(Your Ref: MP09_0162 MOD 4 & MP10_0177 MOD 13)

**COUNCIL RESPONSE TO PREFERRED PROJECT REPORT
MP09_0162 MOD 4 AND MP10_0177 MOD 13**

Submission to Department of Planning &
Infrastructure on Preferred Project Report
MP 09_0162 MOD 4 and
MP10_0177 MOD 13

Prepared by Pittwater Council 26 July 2013

Drawing Name: Landscape Management Zones Stage 1 DA

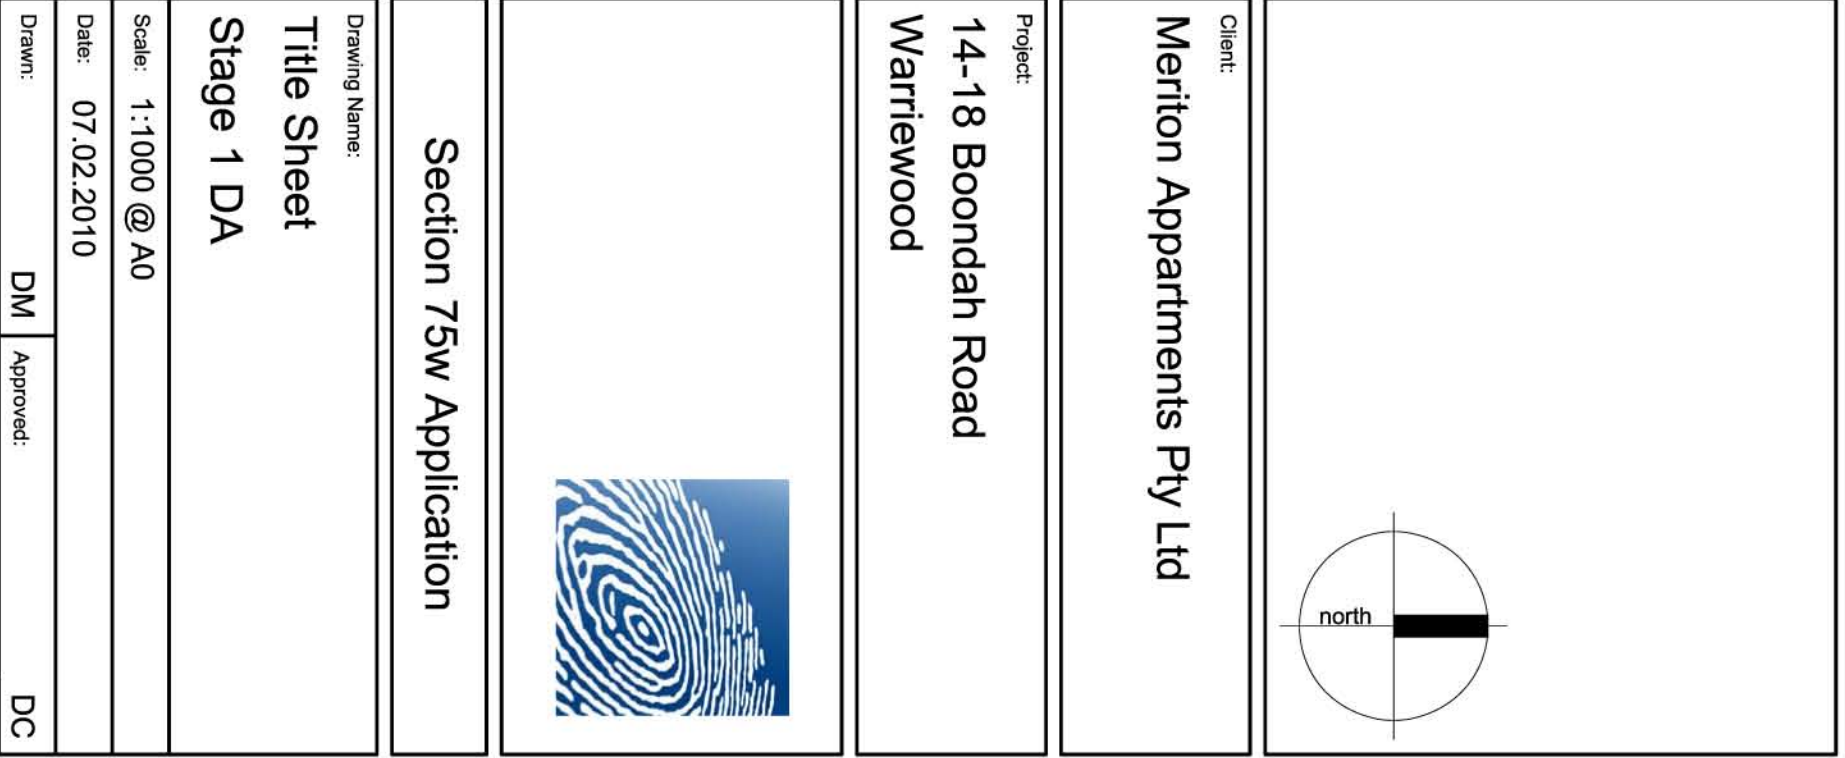
Council reiterates that the full length of the overland flowpath (an area of 2260sqm, shaded green and blue in MAP 1) must be kept as a flood way and a suitable instrument be created to cover that use and its ongoing provision/maintenance by the developer/owner. Council insists this area must not be dedicated to Council and a cash adjustment be made to the payable cash contribution.

- The full length of the overland flowpath (shaded green and blue in MAP 1) must be kept as a flood way and a suitable instrument to covers that use and its ongoing provision/maintenance by the developer/owner.
- Relevant conditions in the Concept Approval and Project Approval regarding the Statement of Commitments and land dedication be amended in the following manner:
 - the amount of land dedicated for active and passive open space on-site (8,920sqm) be revised to 6,660sqm (being the amount less the land containing the overland flow path as shown green and blue in MAP 1); and
 - the cash contribution payable be recalculated (based on a rate of \$325/sqm, being the rate used by the PAC in attributing a value to this land in their original approval MP09_0162).

Project	Development Application Proposed Childcare Centre		
Project address	Lot 502 Macpherson Street, Warriewood		
Client	Meriton		
Title	Site Plan		
Drawn	Scale	Checked	
P.L.	1:200 @ A1		
Job No.	Drawing No	Issue	
2069	DA01	C

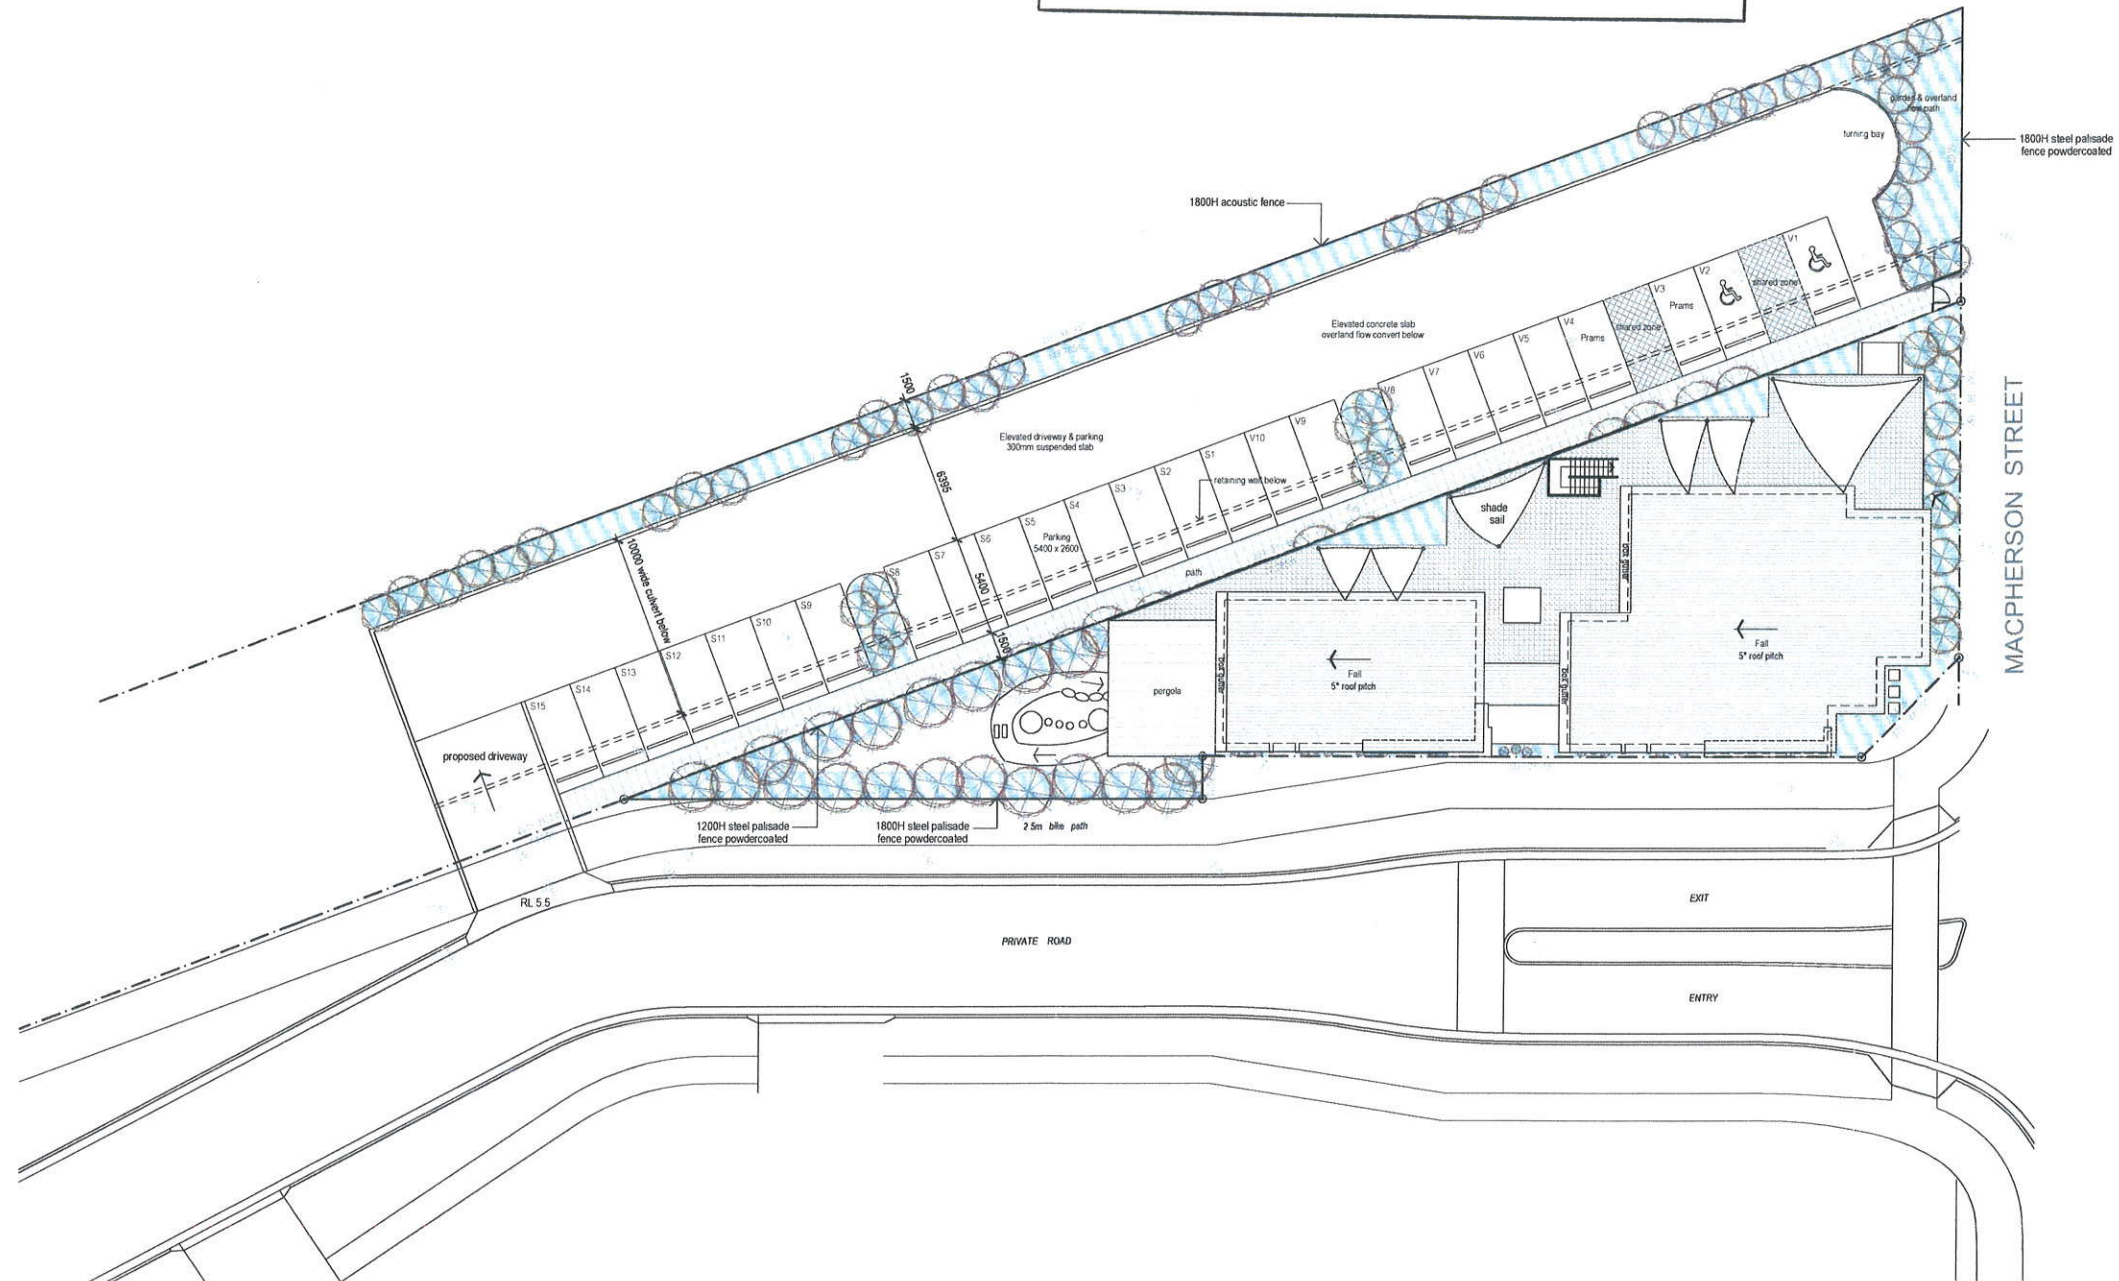
Consistent with the recommendations of the addendum, the carparking plan needs to be amended to allocate ten carparking spaces, located furthest from the centre, to staff, and eleven drop-off/collection spaces to visitors.

Council does not support the consultant's comments within the addendum regarding the carpark layout particularly comments regarding potential conflicts between vehicles entering and exiting the carpark area, and between the internal parking aisle and the driveway. Council recommends that to improve safety and eliminate conflict, a kerb return should be provided on the inside of the turn to facilitate the turning manoeuvre which would require the removal of parking space S15. It is important that a practical and safe car parking configuration is not sacrificed in order to accommodate maximum number of car parking spaces.

Further, the proposed aisle width, being 6.395m, does not comply with the requirements of AS2890 for Class 3A users where the parking space width is 2.6m. This aisle width should be increased to 6.6m. Alternatively, an aisle width of 6.2m would be acceptable if the eleven parking spaces assigned to the drop off/collection of children are increased in width to 2.7m to comply with AS2890.

In order to minimise congestion and conflicts on the private site access road (off Macpherson Street), between traffic accessing the childcare centre parking area and traffic accessing the residential basement carparking areas, it is recommended that 'No Stopping' restrictions are required along the private site access road.

Front Fence Detail (scale 1:50)

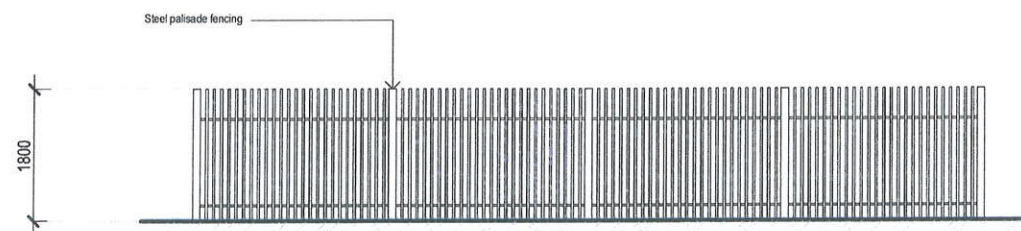
Presumably to screen the built form, a steel palisade fence is now proposed varying in height from 1.8 metres to 1.2 metres, extending from the north west corner of the site to the north west corner of the childcare centre building (along the Macpherson Street boundary), extending south along the western edge of the childcare centre building and around the ground floor outdoor plays area.

From the street this fence will present as a visually hard built element that cannot be softened. It is questionable what effect landscaping along the inside of the fence will have on the appearance of the built form from Macpherson Street.
